Dogger Bank South Offshore Wind Farm

**Appendix K to the Natural England Deadline 3 Submission**

**Natural England's Response to The Examining Authority's First Written Questions  
(ExQ1) and [PD-016]**

19<sup>th</sup> March 2025

Herring

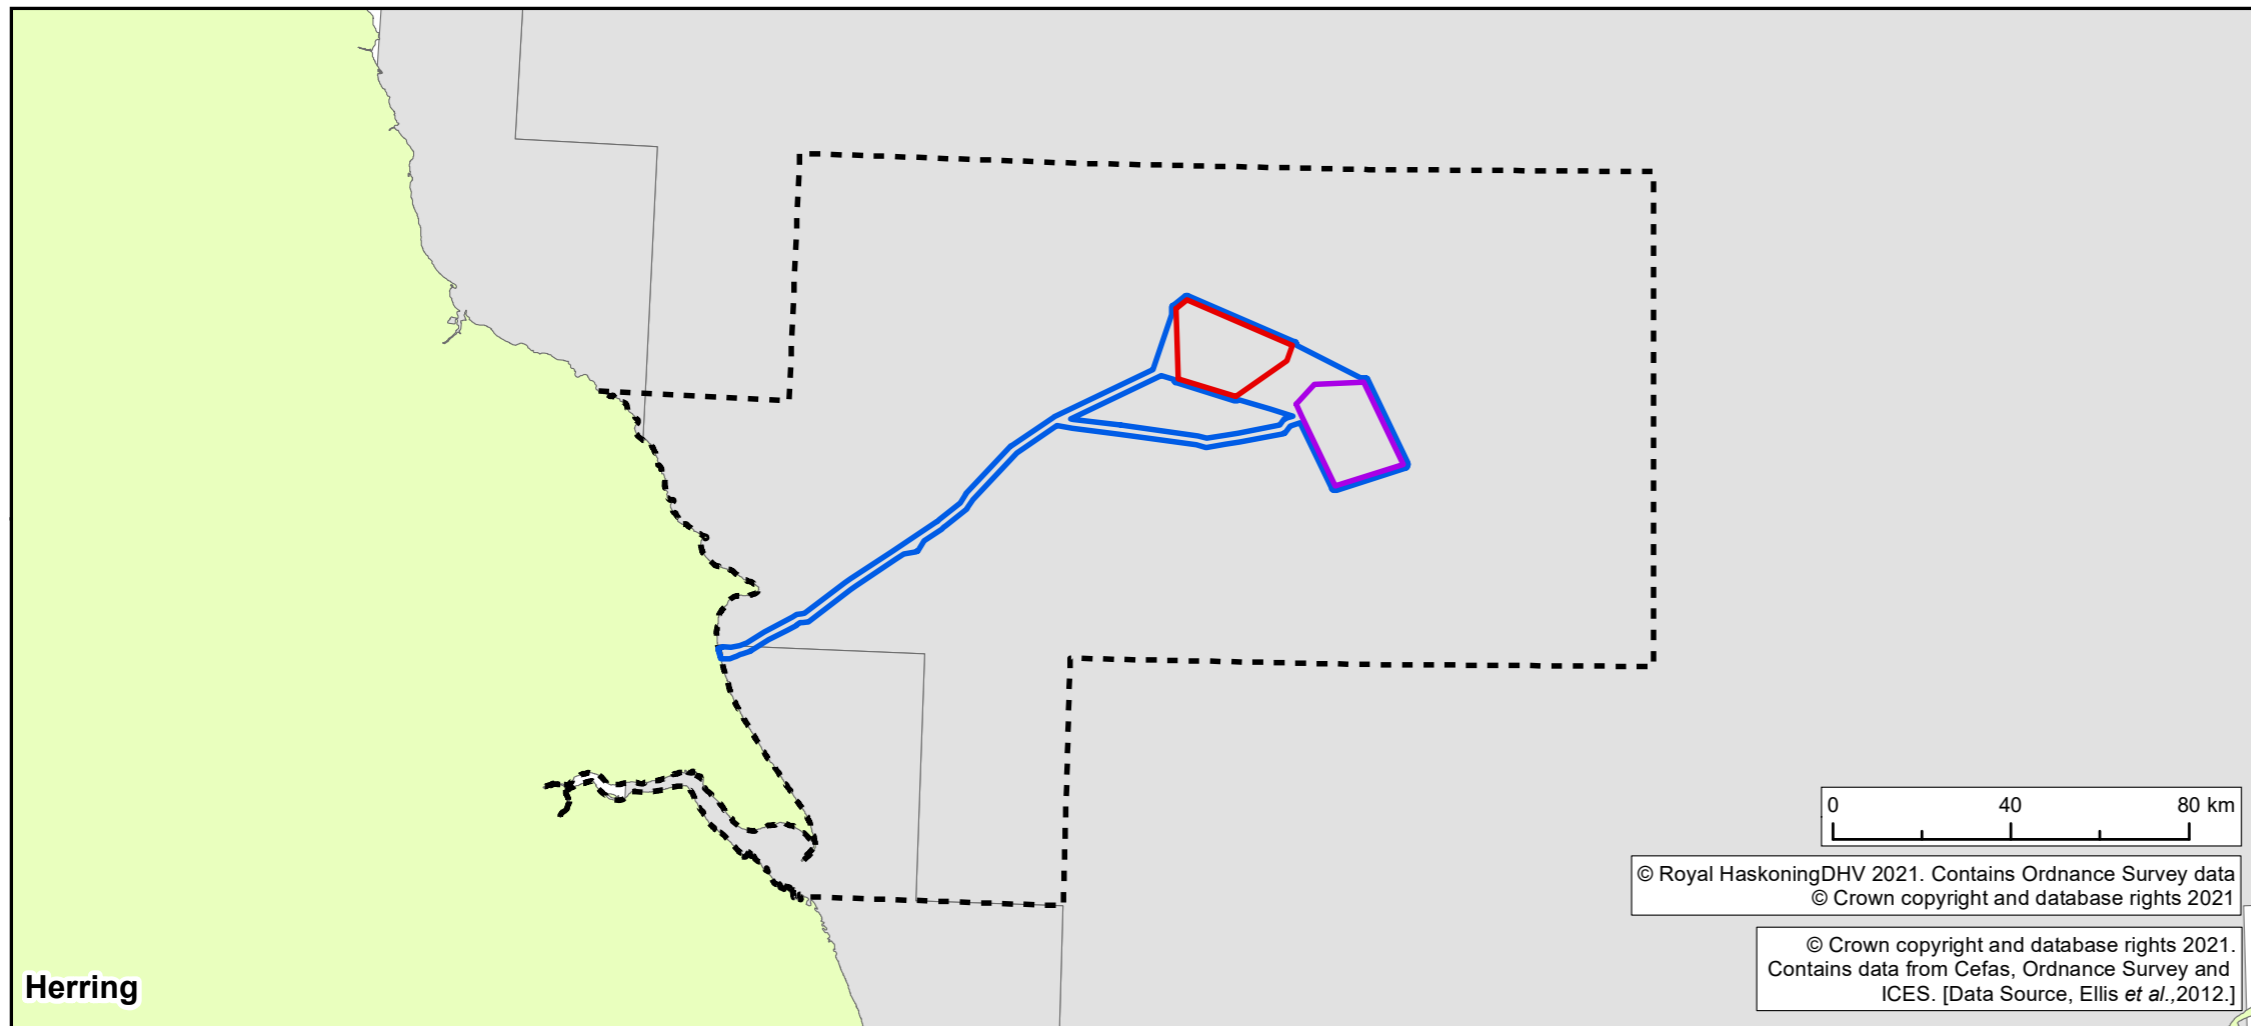
ExQ1	Question to:	Question	NE Response
<b>Fish and shellfish ecology</b>			
FSE.1.1	NE	<p><b>Worst-case location for the assessment of underwater noise impacts on herring</b></p> <p>Action point 34 from ISH2 <a href="#">[EV5-003]</a> stated:  <i>'Natural England <a href="#">[RR-039]</a> stated that the assessment of underwater noise impacts on herring does not use the worst-case location. Provide a response to the suggestion made by the ExA during ISH2 on whether a reassessment based on the most south-westerly point of the proposed DBS West array could result in greater overlap with the 'high' and 'very high' herring spawning potential habitat and whether this could result in a greater impact outcome? If so, would a reassessment be undertaken and submitted?'</i></p> <p>Can you comment on the Applicants' response to this question <a href="#">[REP1-051]</a>?</p>	<p>Please refer to Appendix E3 (Section 1.2) of Natural England's Deadline 3 submission for our detailed response.</p>
